Harnett County

Inspection Report

Permit: BCOM2110-0007

Inspection Type: ROUGH IN

**PROPOSED REFLECTED CEILING PLAN**

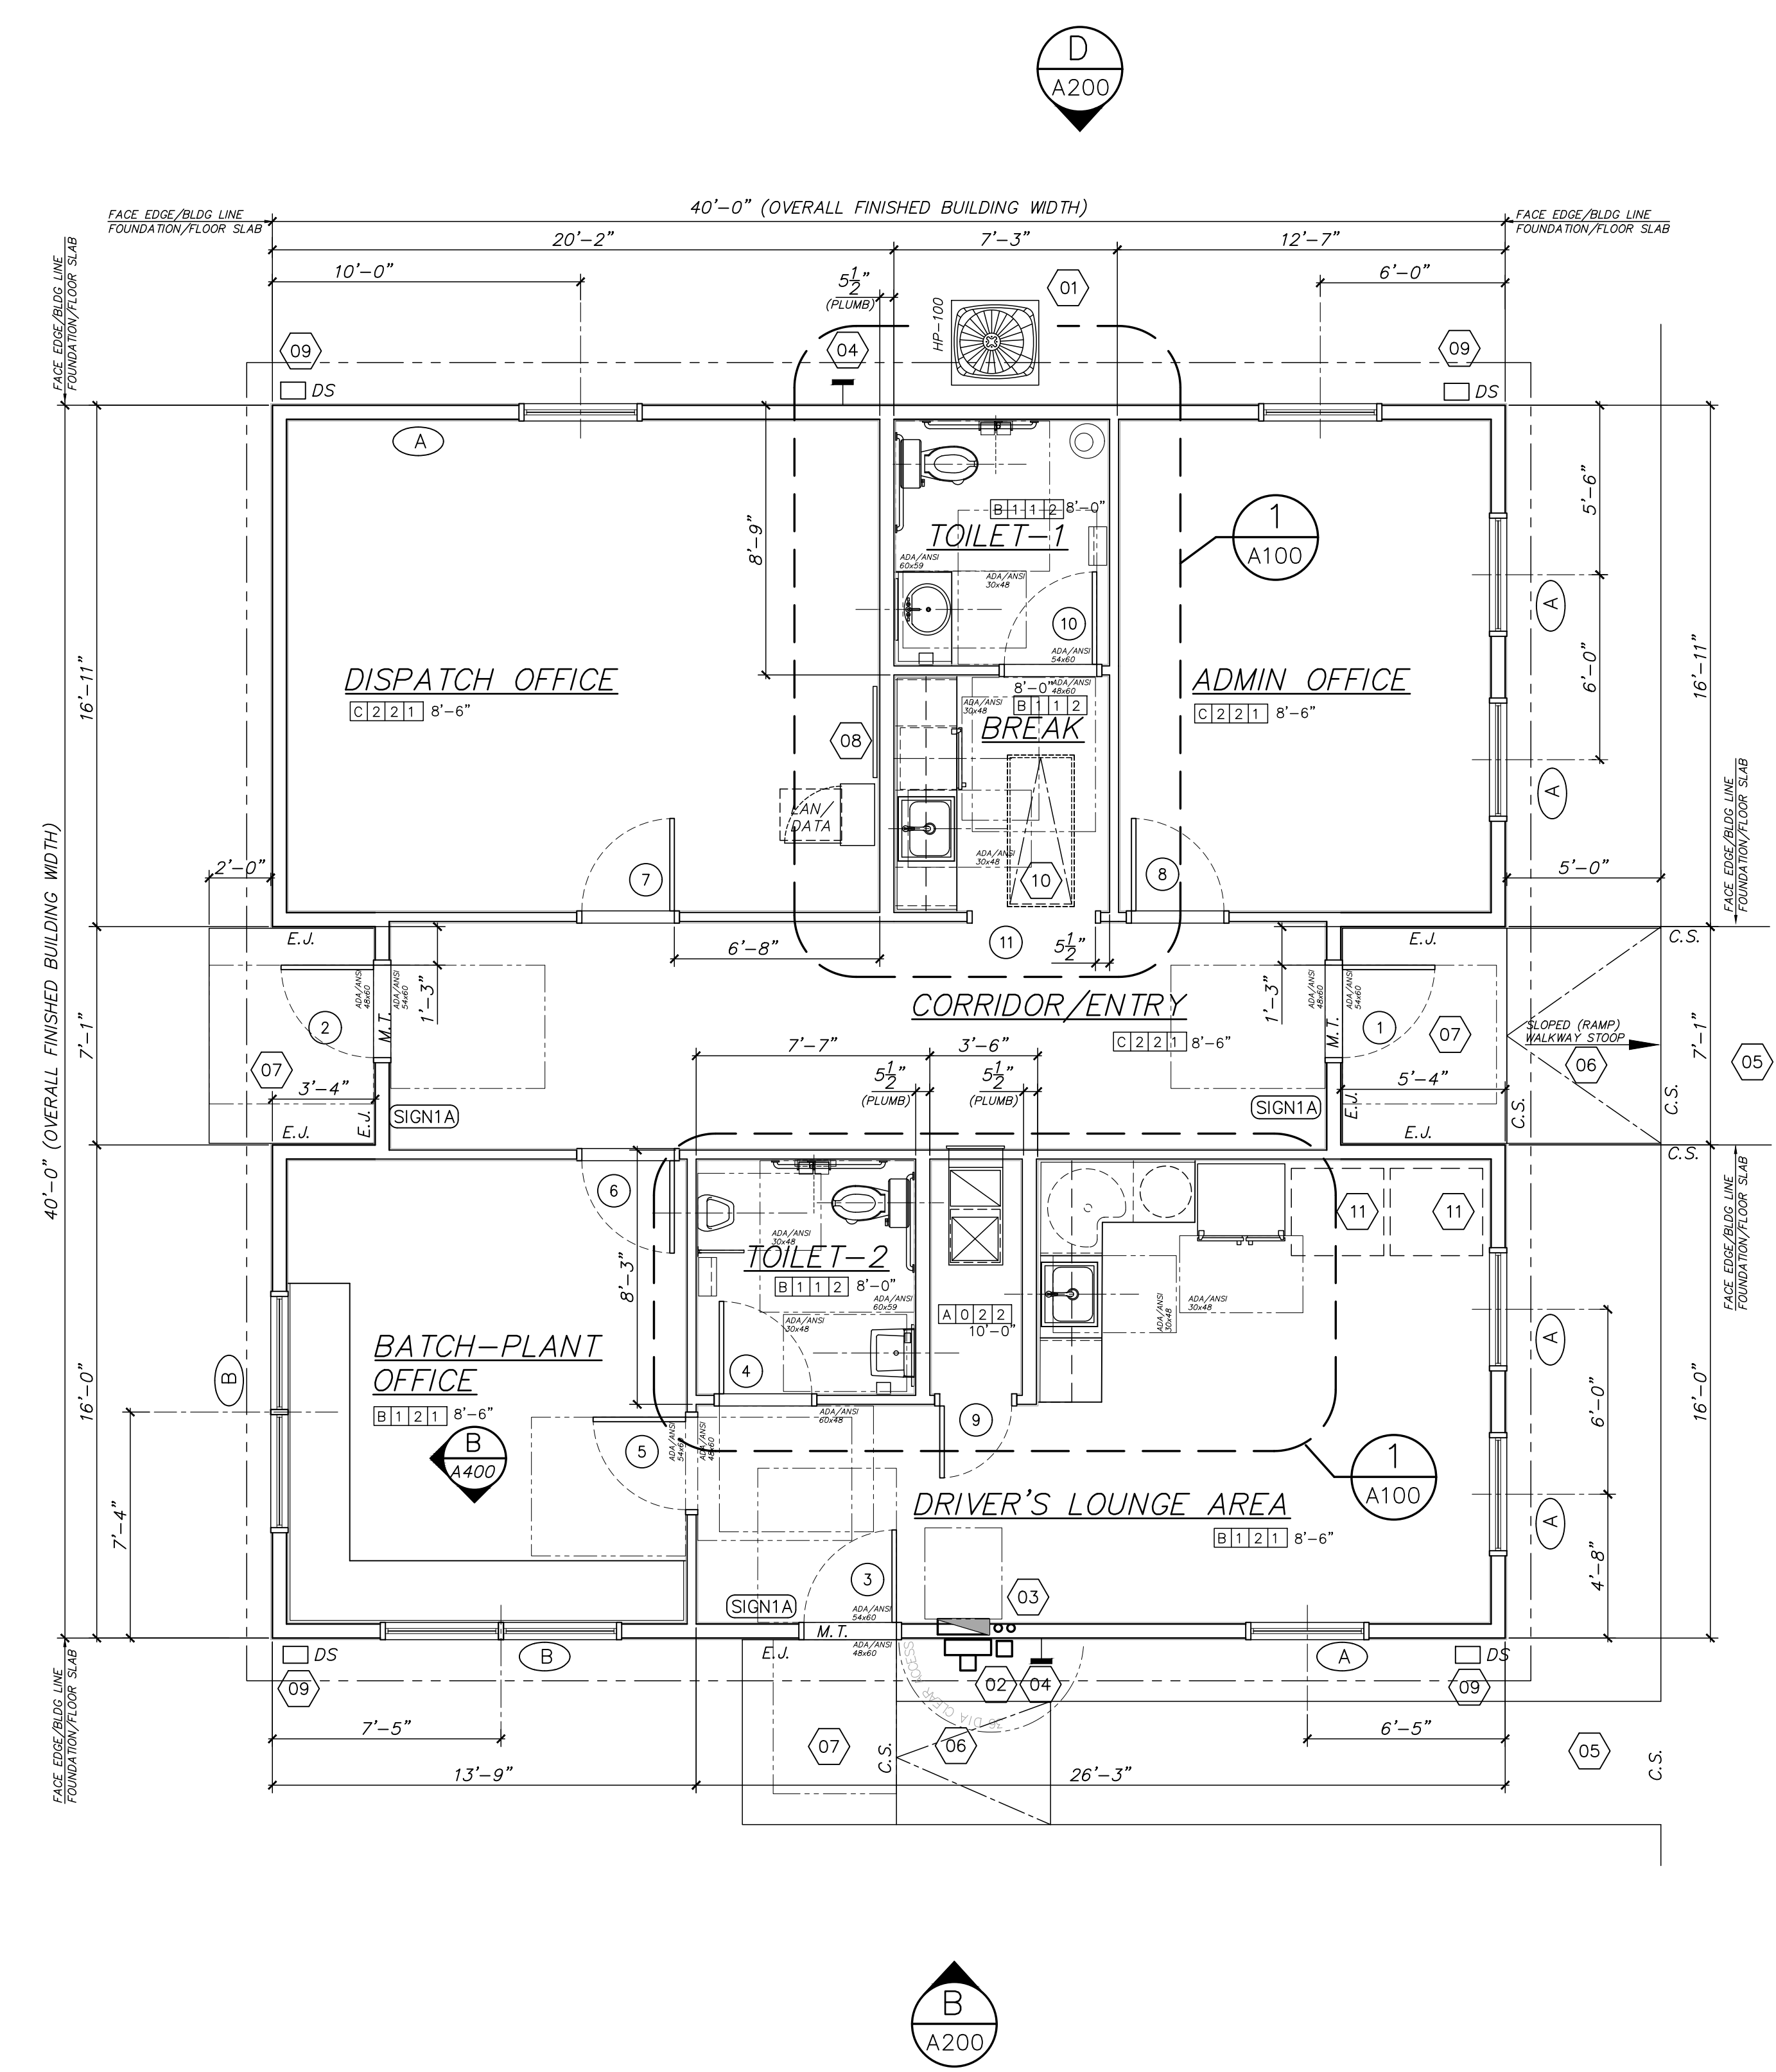
Notes: Need truss documents for inspection. Need ladder to access attic. Ceiling covered before framing inspection.
Fire block/caulk lowered ceiling at bathrooms where missing for plumbing. Could not locate plumbing DWV test.
